May 17, 2019

RE: Initial Review Letter – Requested Major Concept Plan Amendment and Major Master Plan Amendment for a portion of the Greenbriar-Powerwood Development Project
File Nos. CPC CP 01-00148-A10MJ19 and CPC MP 01-00147-A4MJ19

This letter responds to your review letter dated May 2nd, 2019. Our response to the review comments are provided in **Red** below.

## GREENBRIAR/ POWERWOOD MASTER PLAN AMENDMENT

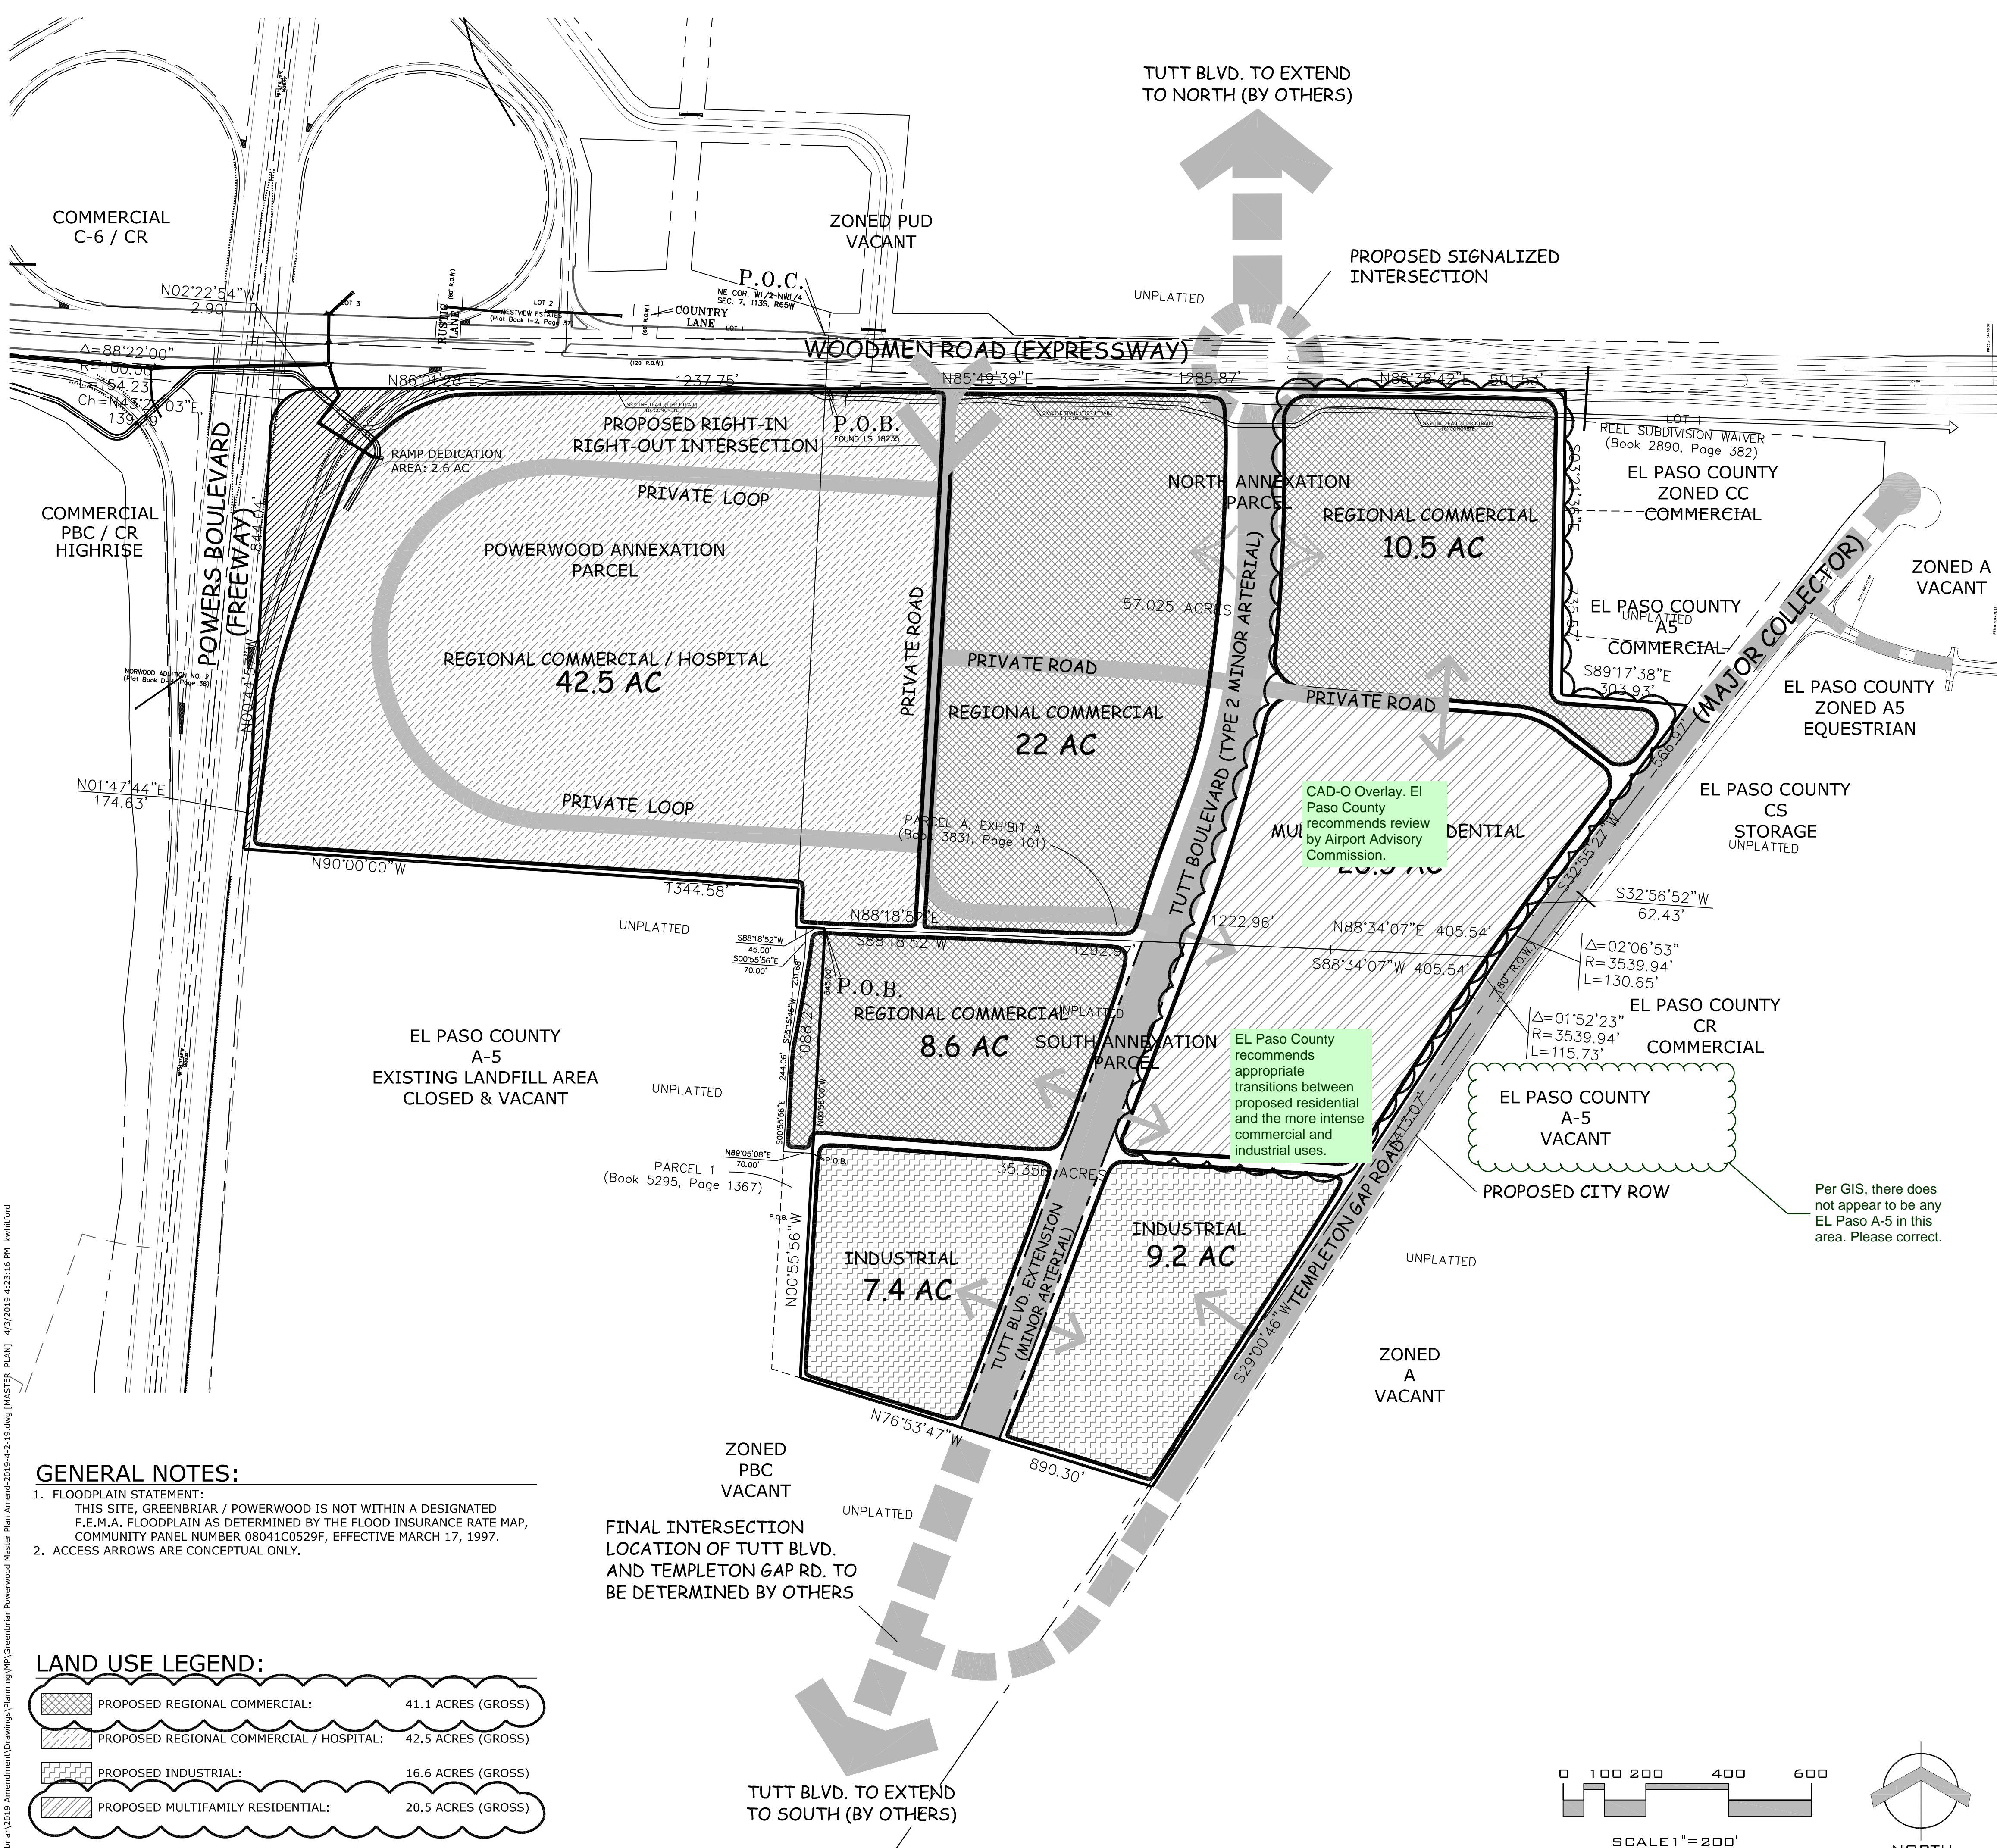
1. Please provide an Amendment History table on the plan.
Amendment Table added.
2. Please update General Note 1, as El Paso County has adopted new Floodplain maps.
Panel numbers and date updated.
3. Please revise the labeling for the multi-family residential pad site to include the proposed density range consistent with the Residential Land Use categorization in City Code.
Density range added.
4. Please label the different portions of the master planned area that have been previously amended. The labels can simply state "Year Amendment".
Clouds and labels added to previous amended areas.
5. Please revise the alignment and designation of the proposed roadway between the commercial and multi-family pad sites based on comments provided by Traffic Engineering Division under the concept plan amendment application.
See response on Concept Plan Amendment comment.

1. Please revise "general note 1, floodplain statement" to the recently approved revision to the effective date and panel number.
Panel numbers and date updated.

1. Please address/respond to the comments provided on the attached redlined plan.

Comment 1: Existing adjacent zones corrected.

Comment 2: Airport Advisory Commission is notified of MPA submittal as within Airport Overlay. The AAC had no comments on the submittal.

Comment 3: Development will provide buffer and screens as required by city code between residential and non-residential uses.
